CITY OF ALBUQUERQUE

June 11, 2018

RE: **Juan Tabo Hills Park**
Grading and Drainage Plan for SPBP – Disapproved
Engineer's Stamp Date: Missing (M22D017A)

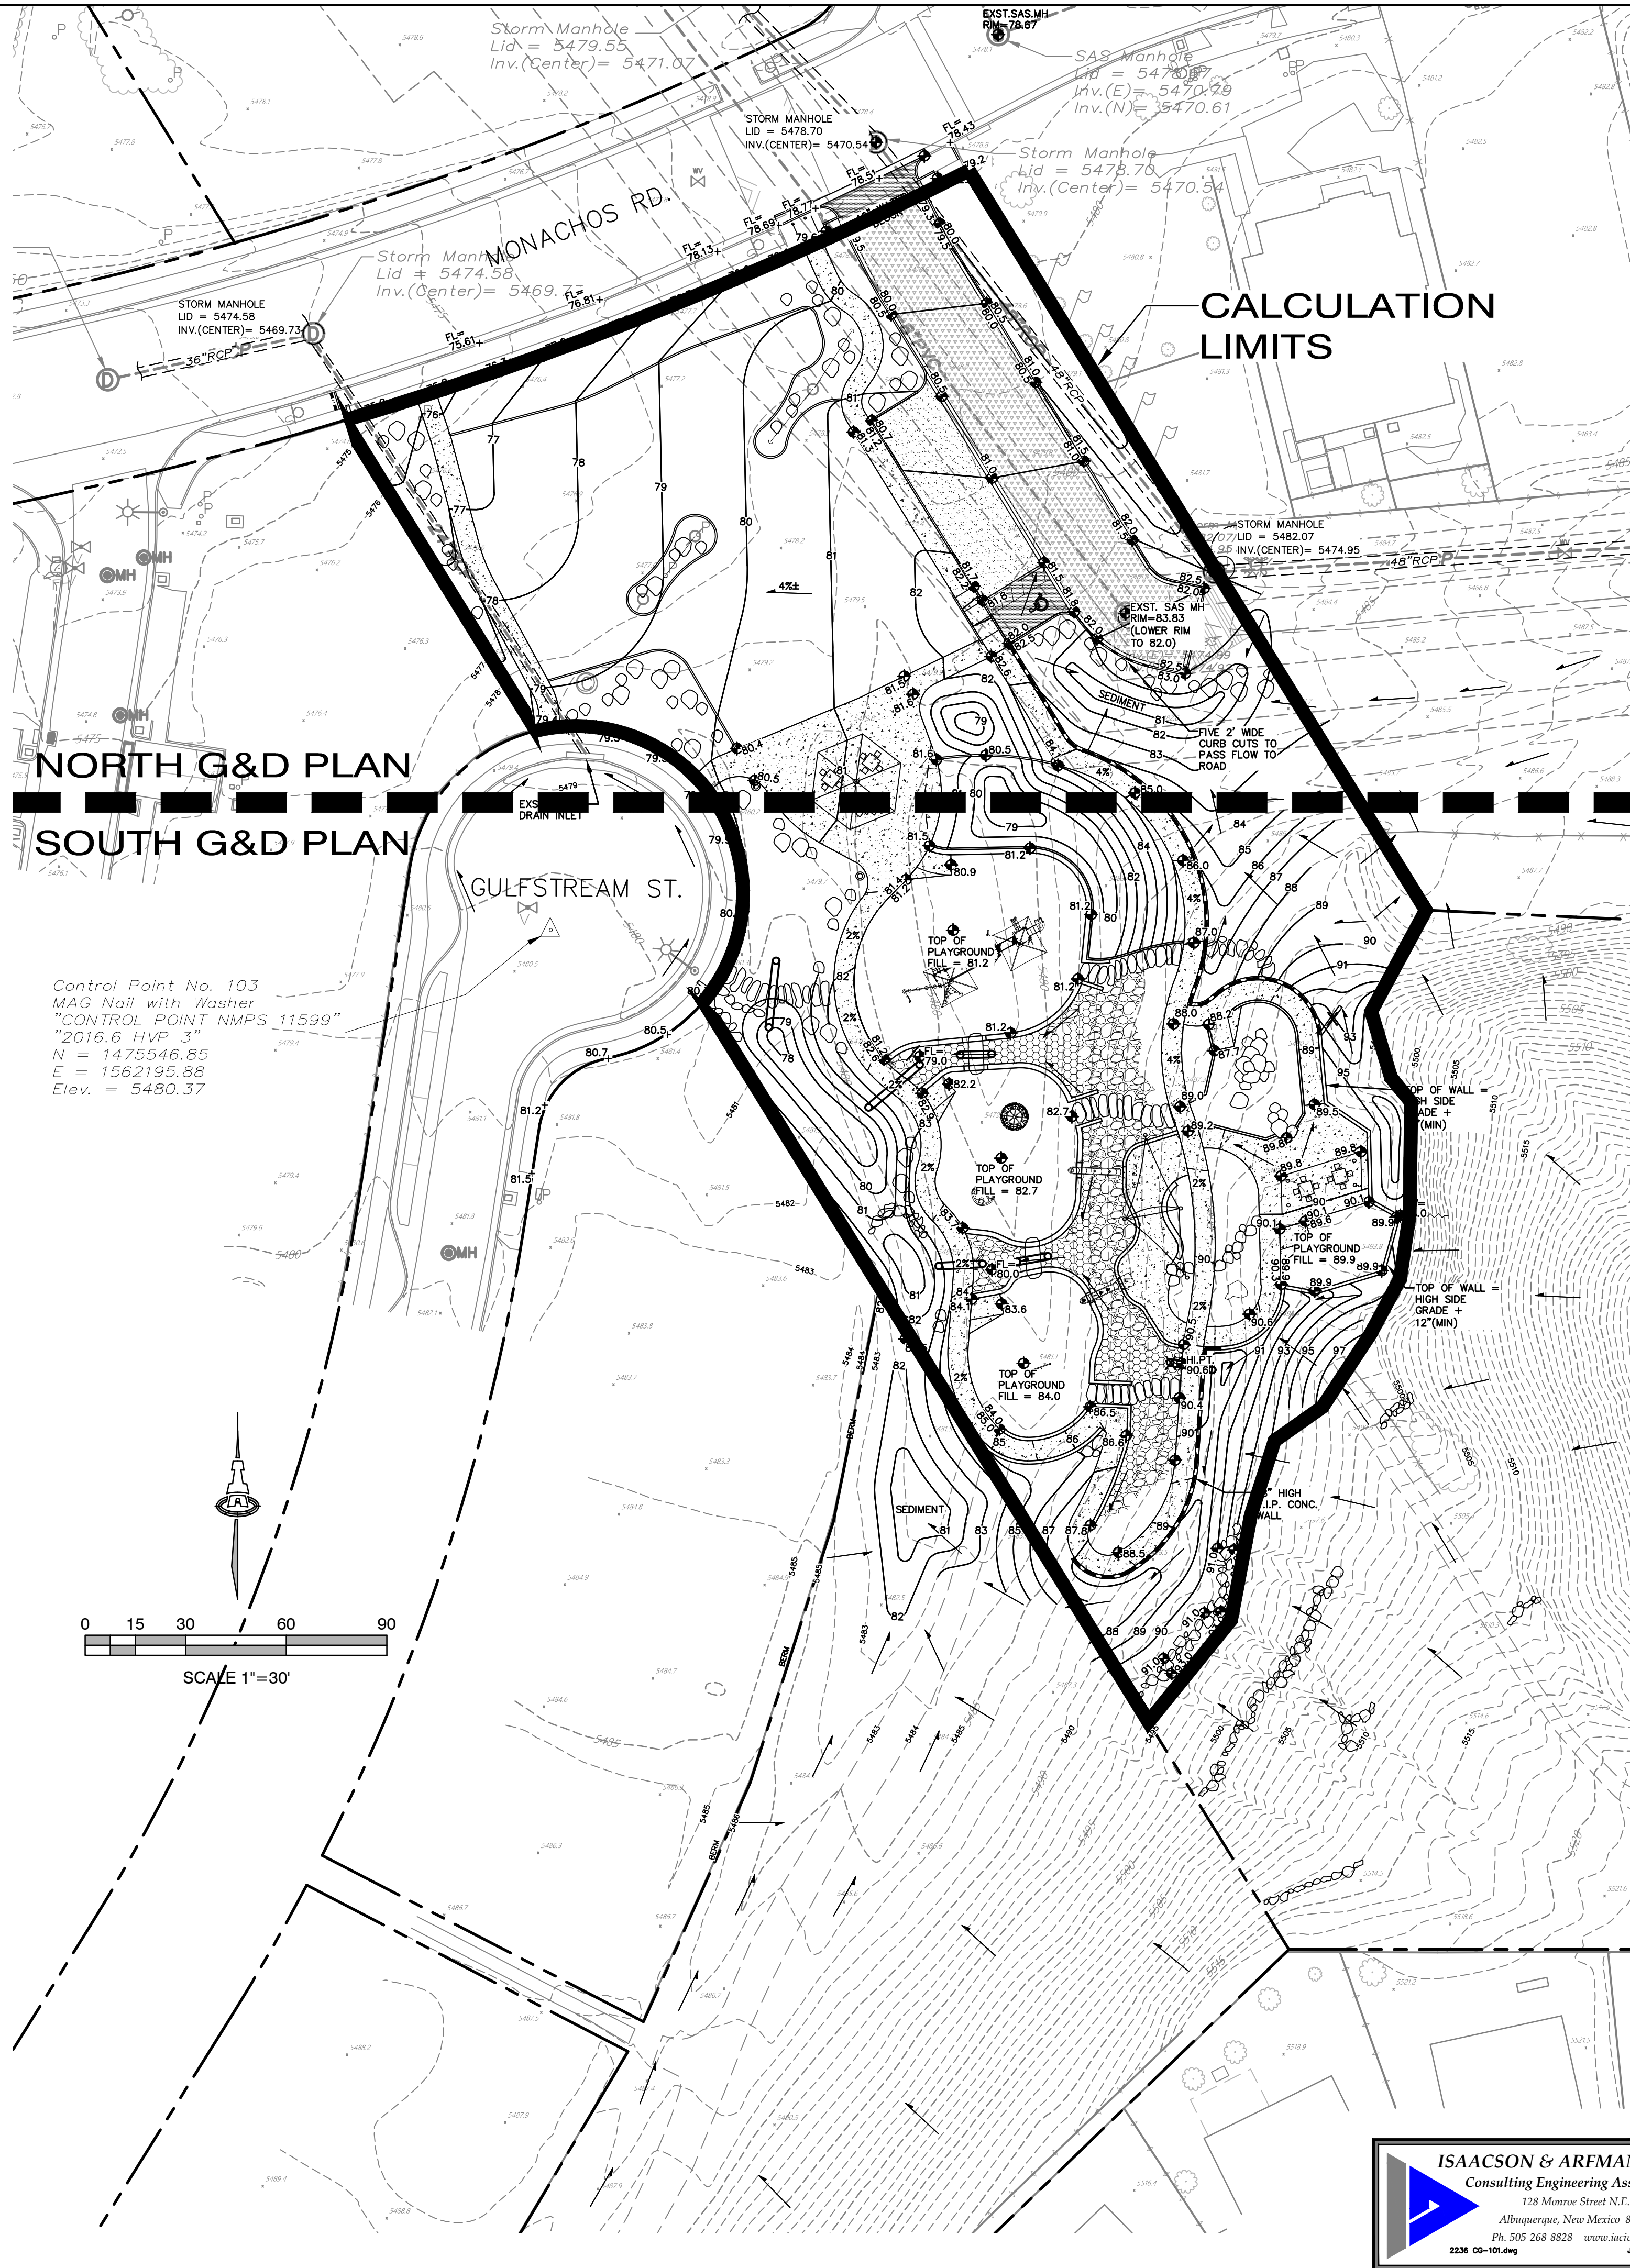
3. The layout must be revised so that the swale on the southwest side of the site remains unobstructed. The Playground includes more than 3' of fill in the swale, which may force drainage from the swale into the private lots west of the park. The playground may need to be shifted east to avoid blocking the swale. Capacity calculations are required for the swale, and must include 1' of freeboard.

6. Capacity calculations are needed for the swale running down the west side of the park between the Gulf Stream cul-de-sac and Monachos Rd. to insure that drainage does not cross into the private lot west of the park.
